From: Ewan Stewart
Sent: 07 August 2024 09:42
To: Suzanne Taylor
Subject: 23/01586/REM Himley Village

I have looked at the resubmission for the above application and can confirm that Strategic Housing support the revised tenure mix.

HIMLEY VILLAGE, BICESTER - PHASE 2A - BOUNDARY TREATMENTS PLAN

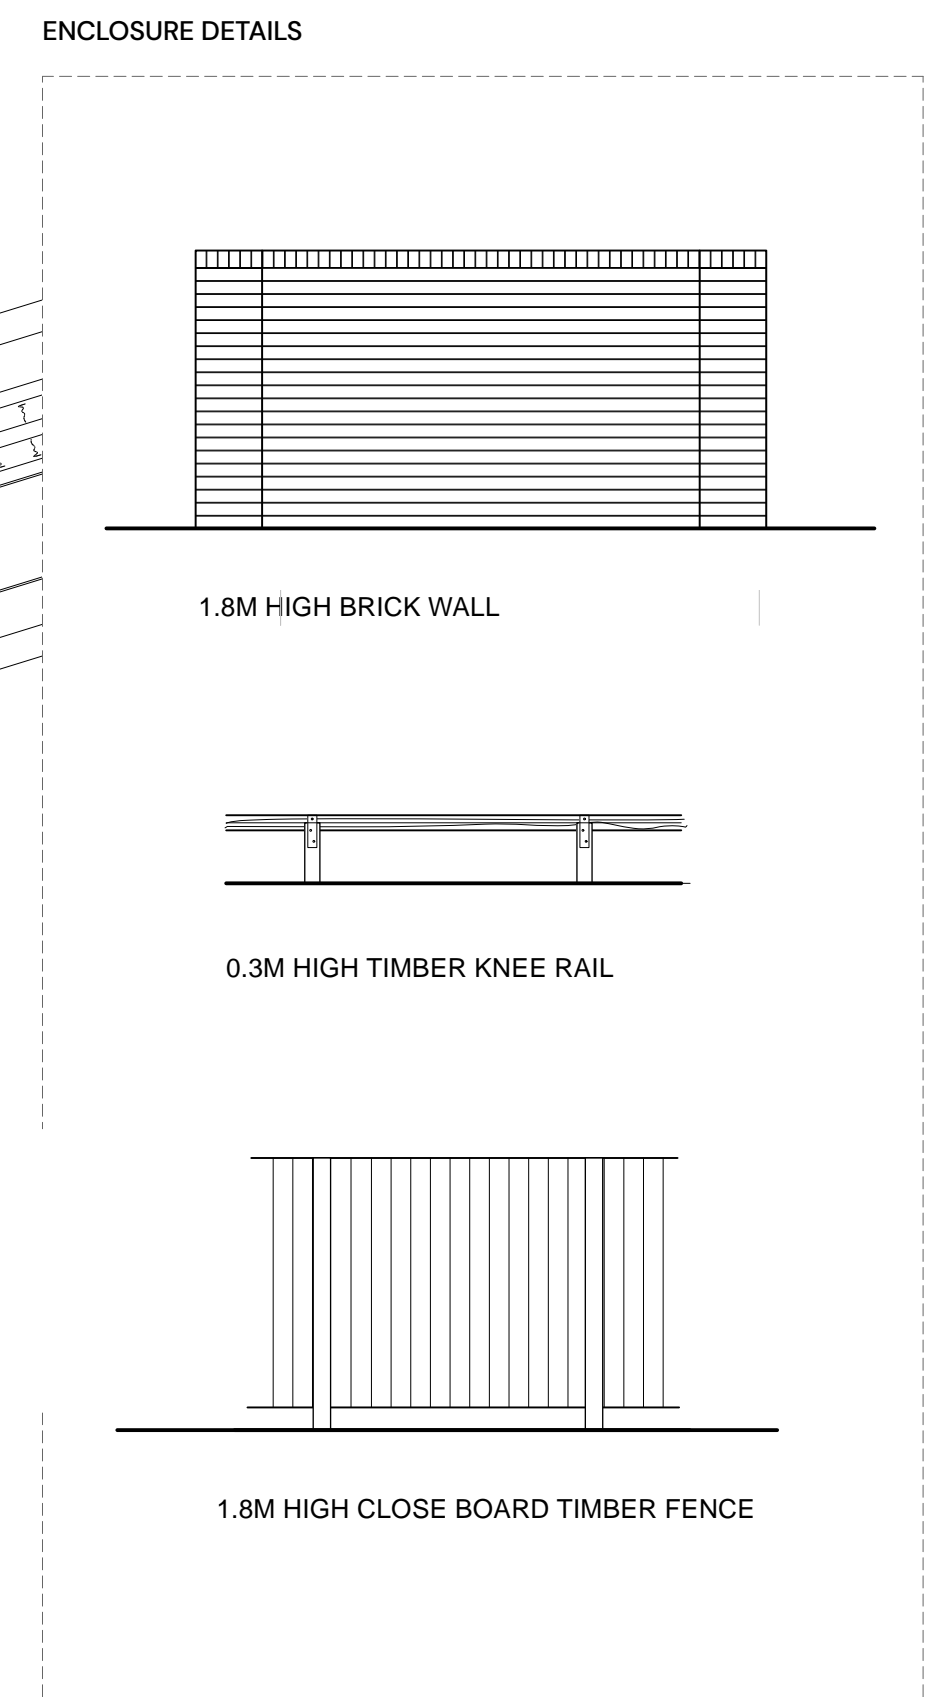
The only comment I have on the plans is that the layout is very cramped where plots 90 – 106 are located. There are 14no rented dwellings in this section which I would view as a cluster and therefore too many. The Developer Contributions SPD requires no more than 10 units of one affordable tenure in a cluster.
